THE HILLS SHIRE COUNCIL

15 March 2018

Council received notification on 5 February 2018 of a Section 75W application made to the NSW Department of Planning and Environment to modify a Part 3A approval for a seniors living development at 34-36 Memorial Avenue, Kellyville.

DA404
B

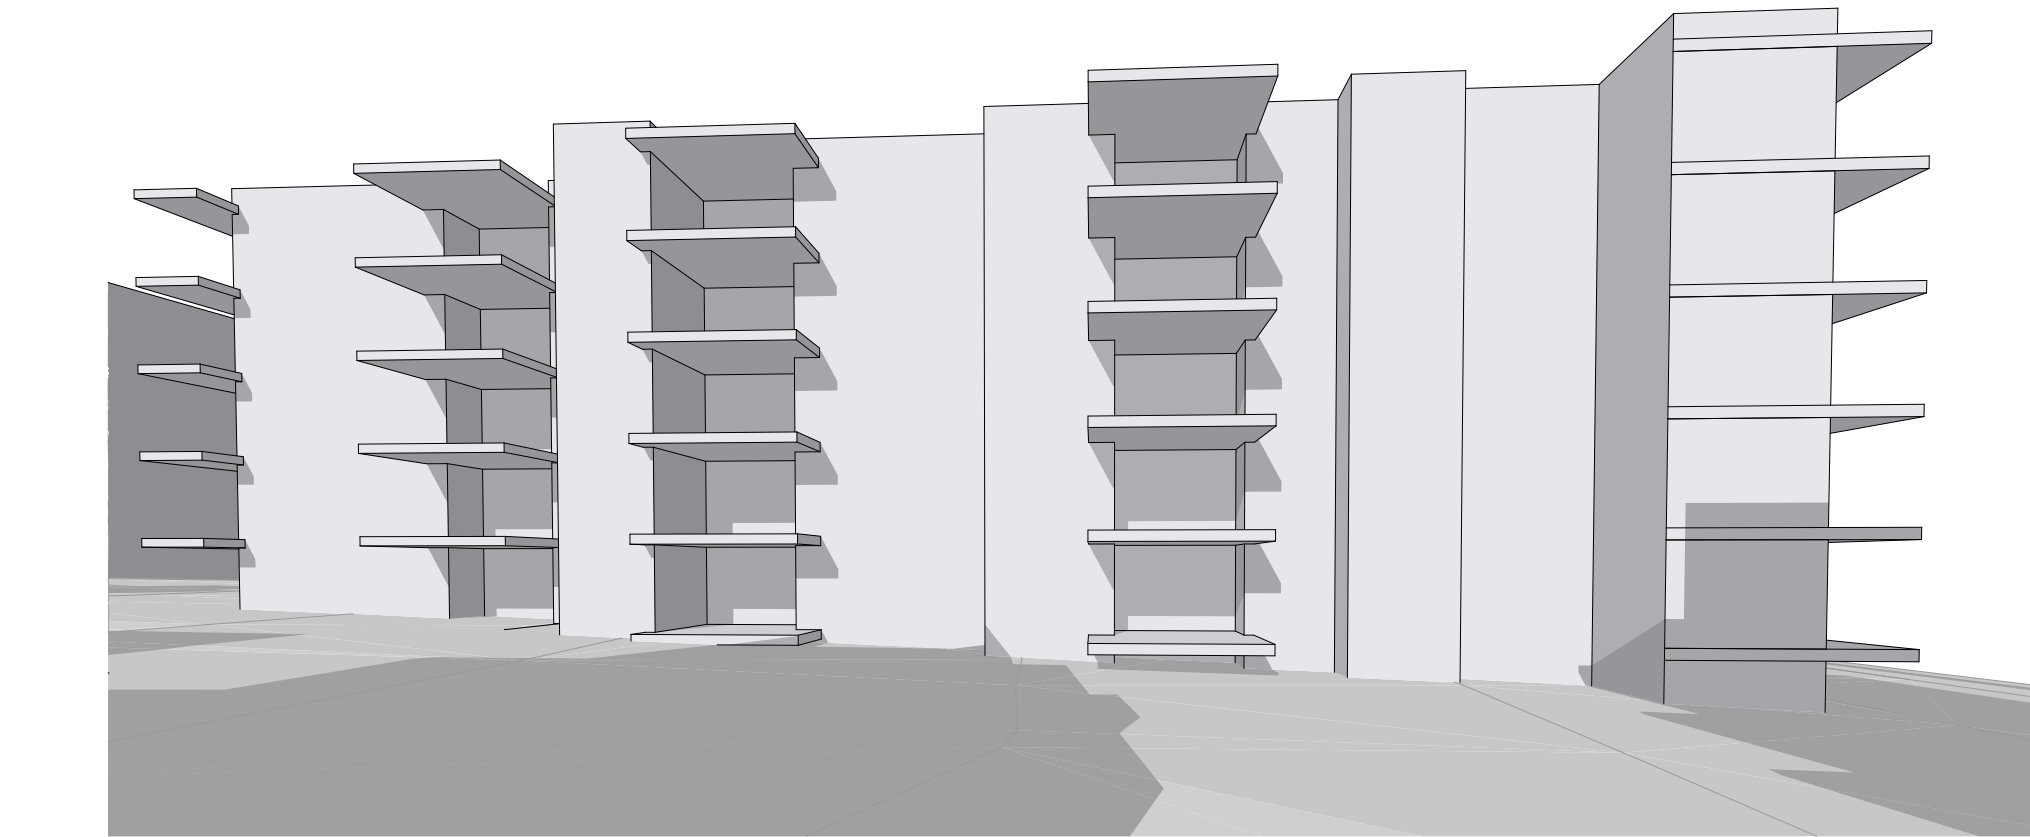
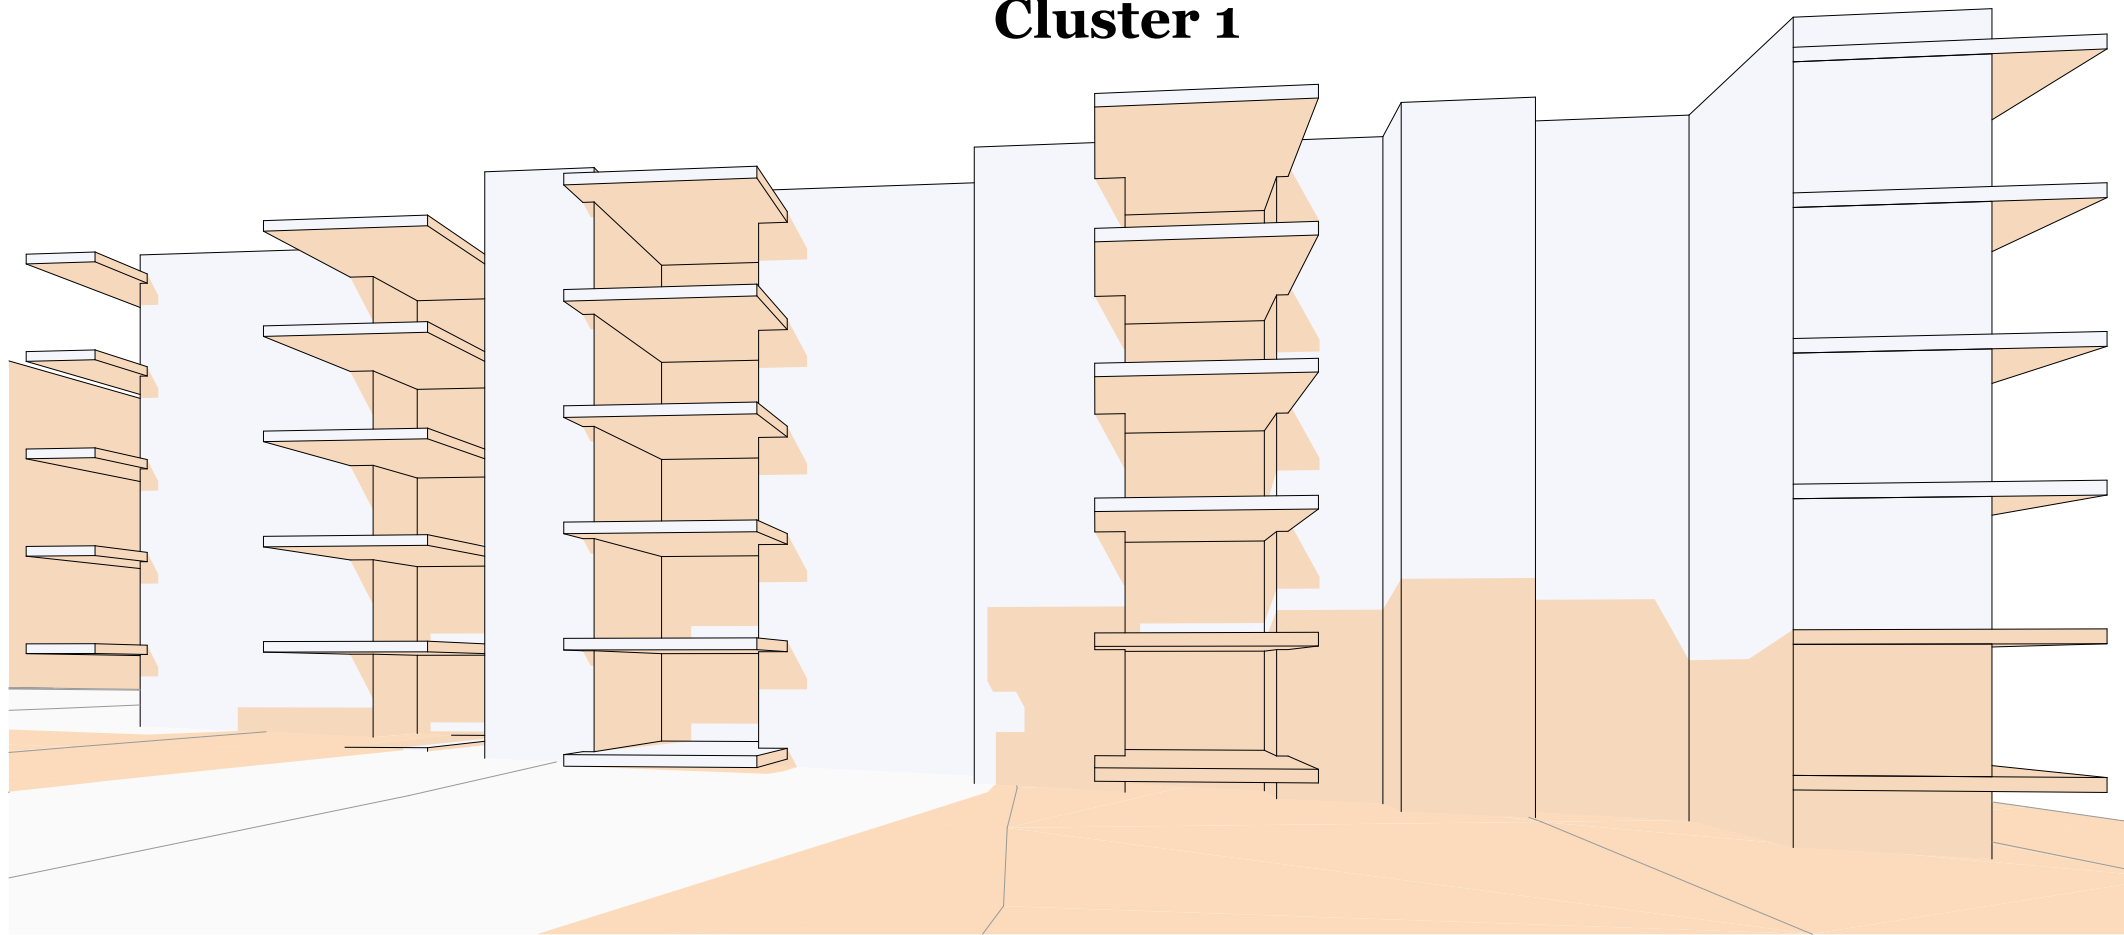
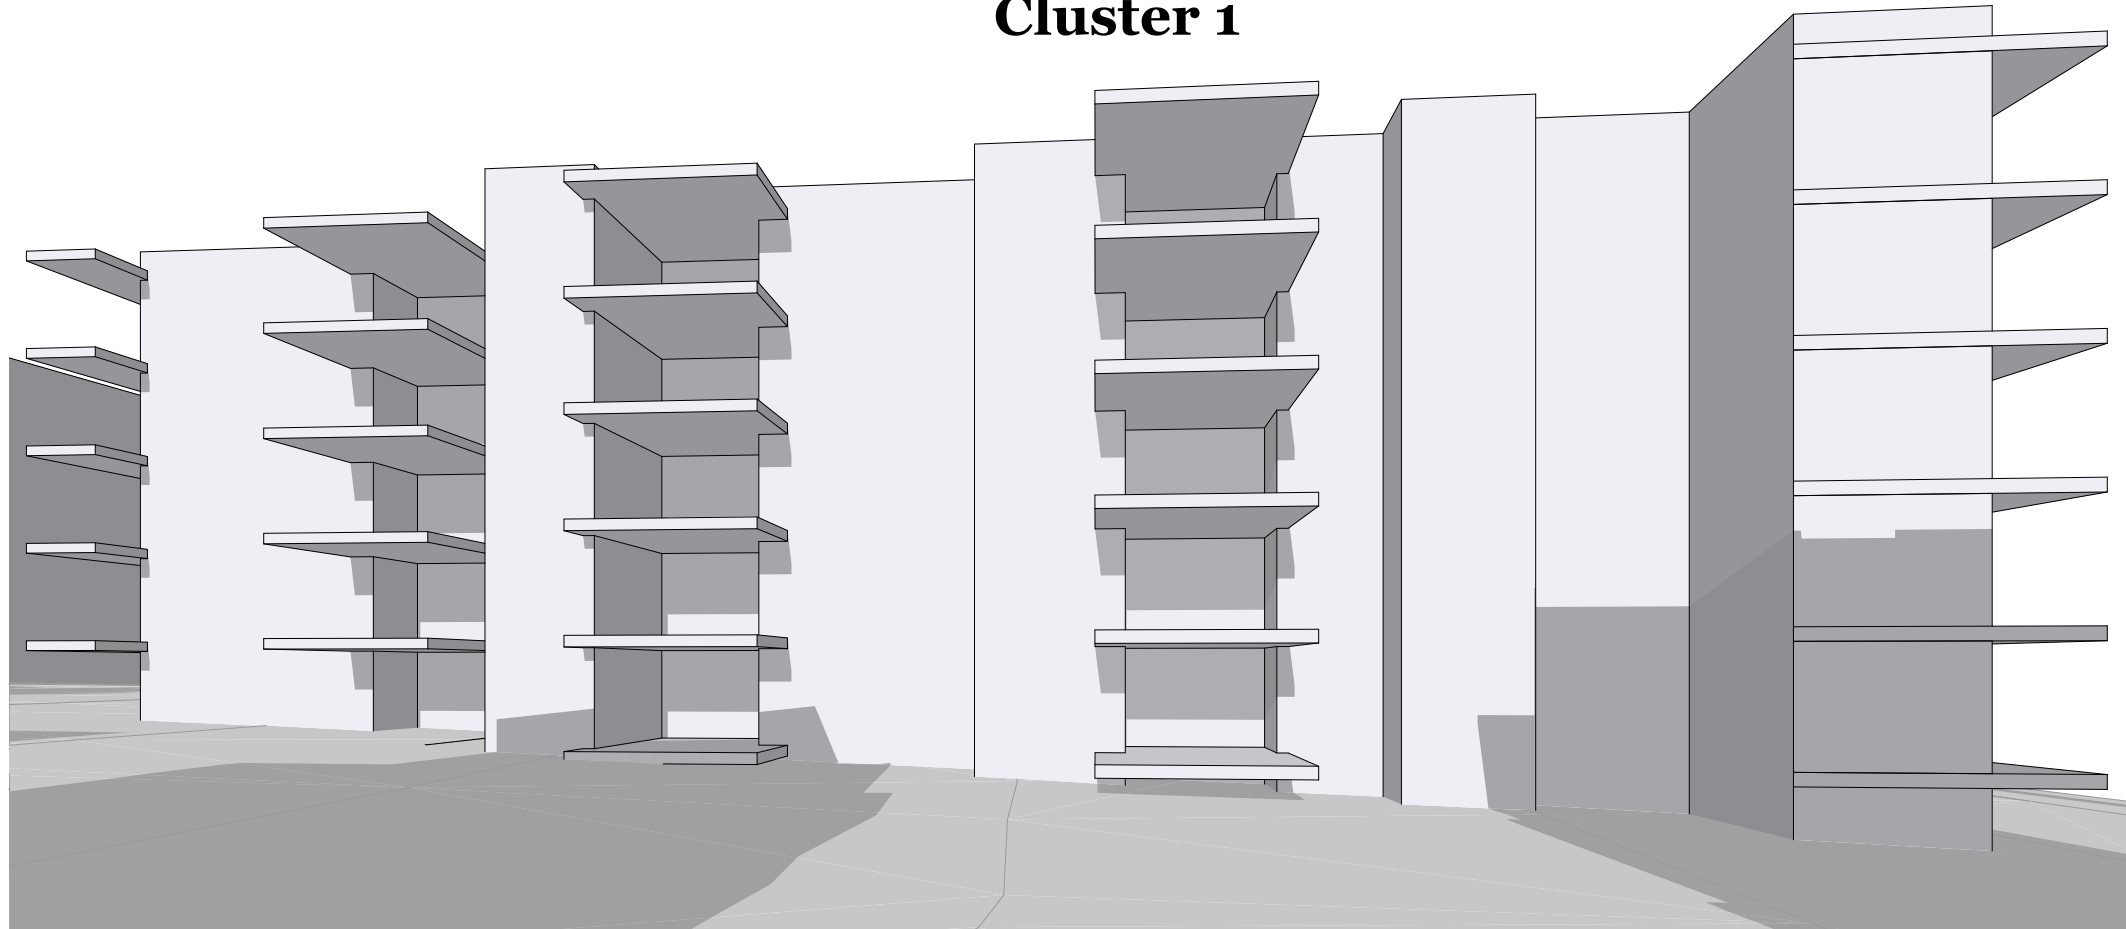
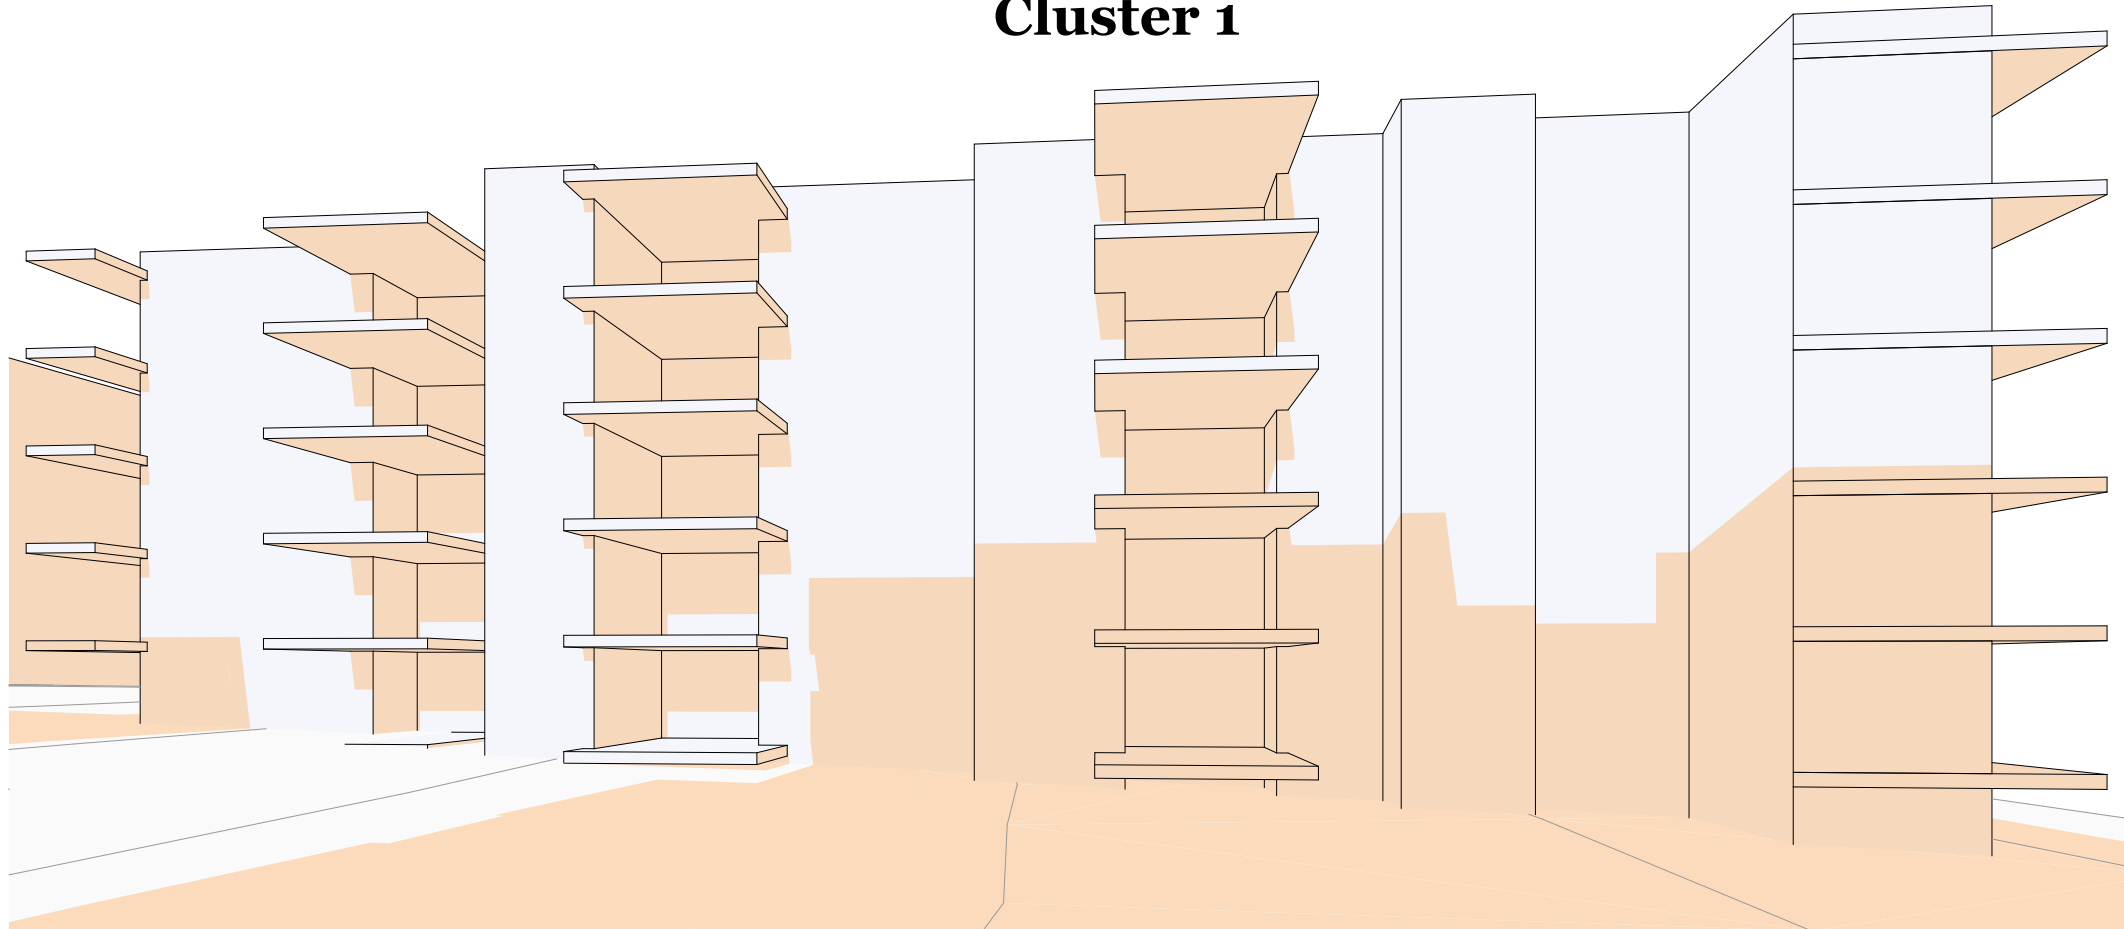
- The proposal has not provided a clear assessment of the proposals impact on the solar access afforded to adjoining buildings known as Cluster 5, or the RACF impact on the solar access afforded to the proposed buildings. Analysis similar to that provided for Cluster 1 should be provided to the northern elevation of Cluster 2, 3 and 4 (to assess the impact of the RACF), and the northern elevation of Cluster 5.
